KITITAS COUNTY COMMUNITY DEVELOPMENT SERVICES

RE: McIntosh Segregation, File Number SEG-07-66
Assessor's map number: 18-18-08010-0001

Kittitas County Community Development Services has reviewed the proposed parcel segregation application and hereby grants **final approval** to the referenced application. Pursuant to Kittitas County Subdivision Code Chapter 16, please note the following items that must be completed to complete the process:

35-199

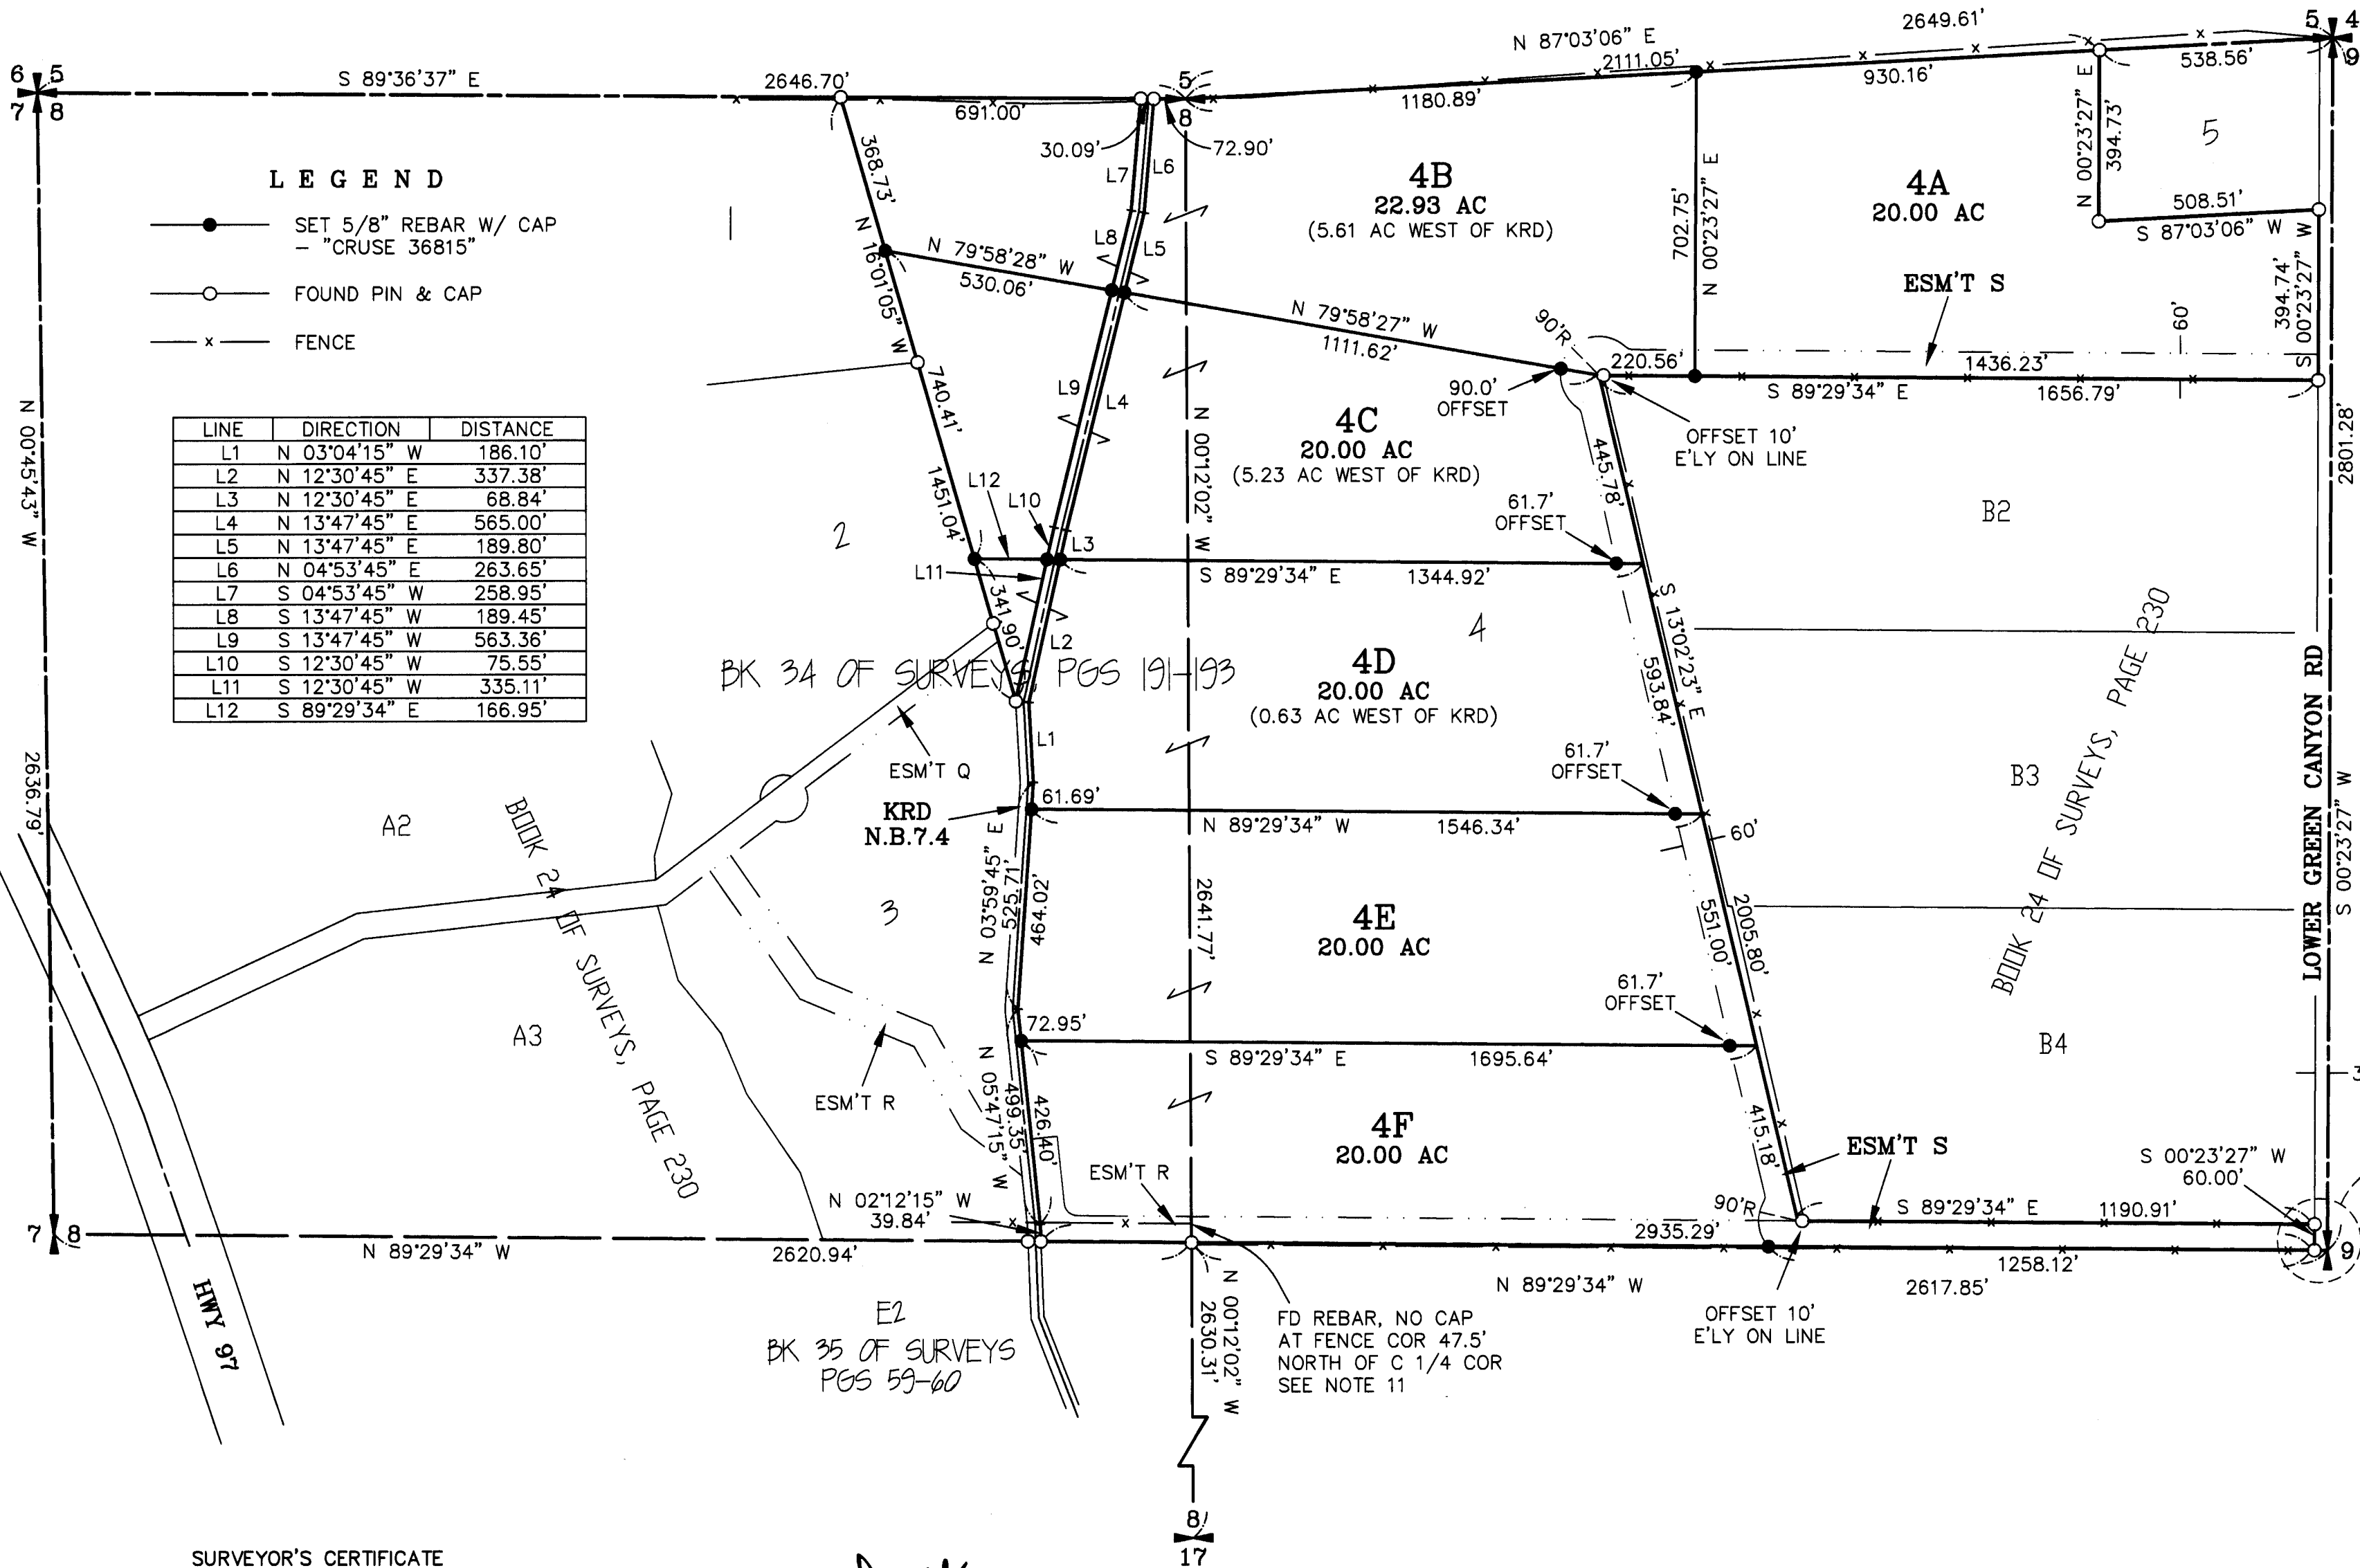
The Public Works Department has reviewed the Request for Parcel Segregation Application. In order to ensure that it meets current Kittitas County Road Standards, the applicant needs to provide the following prior to final approval:

1. The proposed access with appropriate easement(s) shall be shown and shall conform to applicable Kittitas County Road Standards.
2. A revised legal description that describes the final configuration of the subject property shall be required.

1. Access: All access shall be from Lower Green Canyon Road.
2. Private Road Certification: Private roads serving any of the lots within this development shall be inspected and certified by a licensed professional engineer for conformance with current Kittitas County Road Standards, 9/6/05 edition. Kittitas County Public Works shall require this road certification to be completed prior to the issuance of a building permit for any of the structures within the proposed plat.

3. Private Road Improvements: Access shall be constructed as a Low-Density Private Road. See Kittitas County Road Standards, 9/6/05 edition.
 - a. Access easements shall be a minimum of 60' wide. The roadway shall have a minimum width of 20', with 1' shoulders, for a total width of 22'.
